**From:** Contact Centre (CRM) <contact@ribblevalley.gov.uk>  
**Sent:** 05 January 2026 19:28  
**To:** Planning  
**Subject:** Planning Application Comments - 3/2025/0100 FS-Case-781726031

**Planning Application Reference No.:** 3/2025/0100

**Address of Development:** Parking / deliveries / Utilities

proposed site plan
scale - 1:250@ A1 / 1:500 @ A3

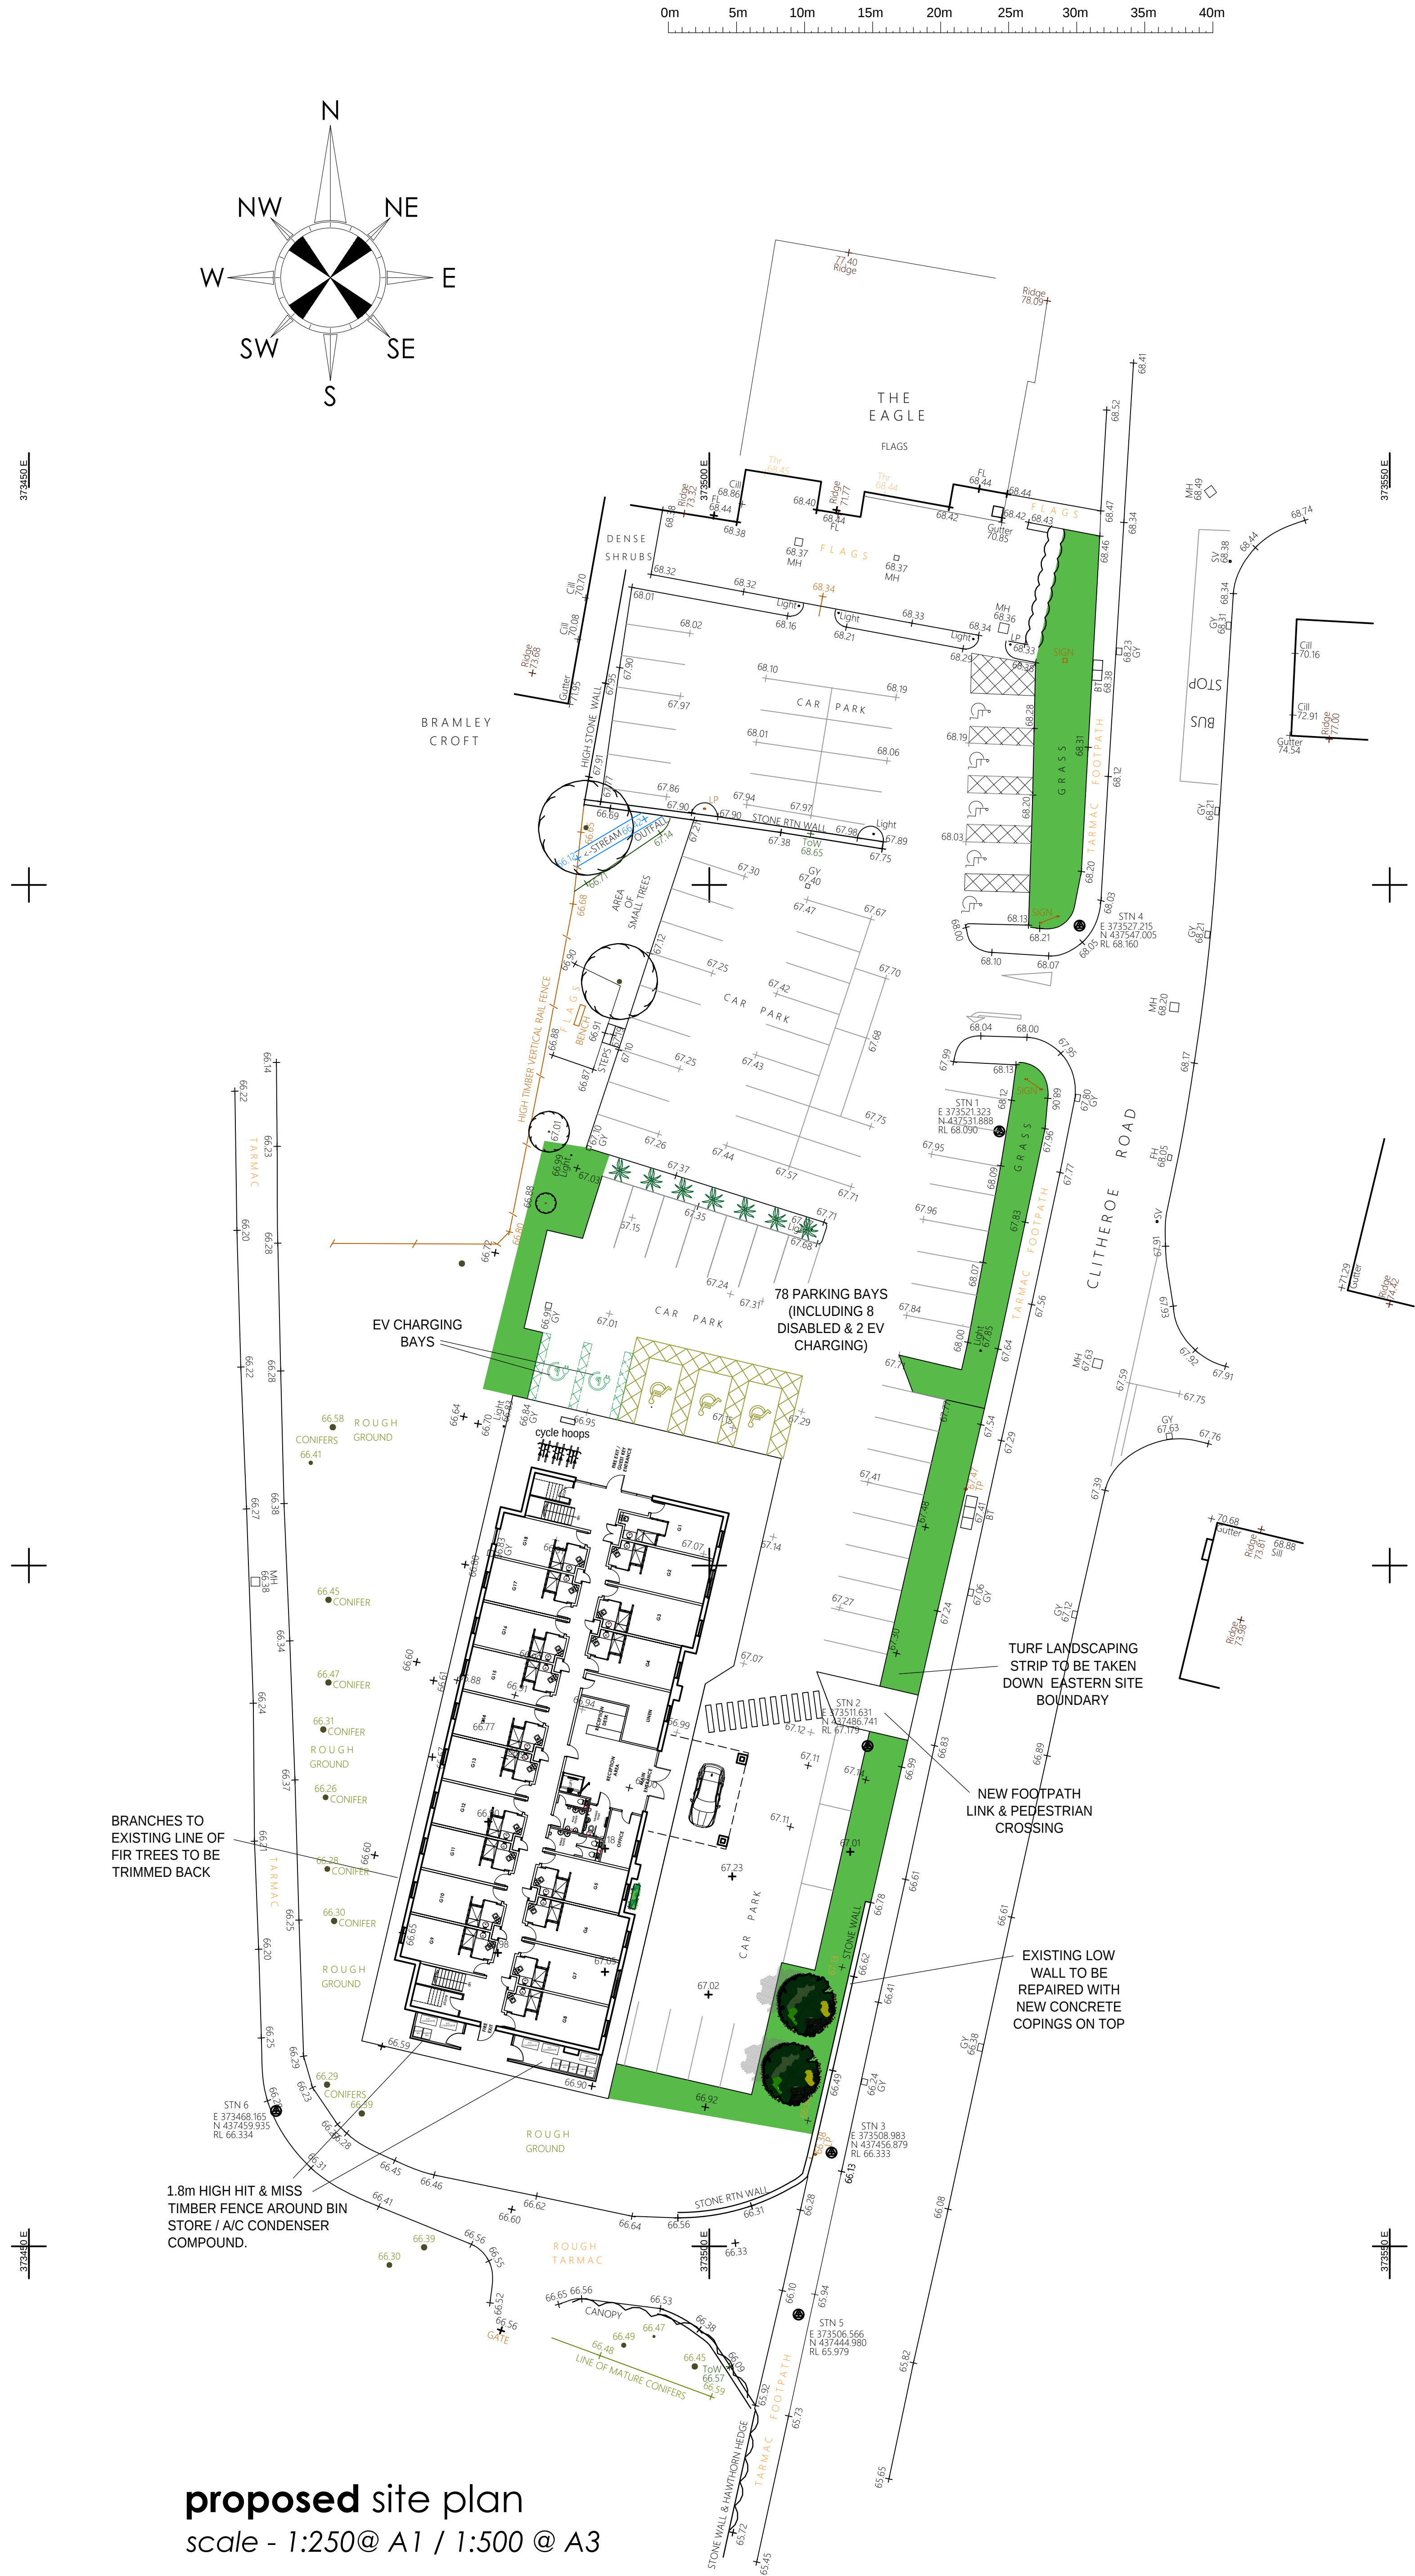
**Comments:** This will have a major impact on the local residents as the car park overflows now without reducing the numbers and building a hotel this will then mean cars paring on the road at a particularly fast section where cars are meant to be slowing but do enter the 30mph at far greater speeds. We also have concerns for light pollution and supporting transport for food drink & laundry which will be required daily & this is not mapped out sufficiently and numbers not quoted, this needs to be done to demonstrate it works. The new electrical load calculation are not shown as the building will need a 150/200kva supply dependent on the kitchen capability again not local ENWL connection point shown or local SS shown as this will also be required for the EV charging.
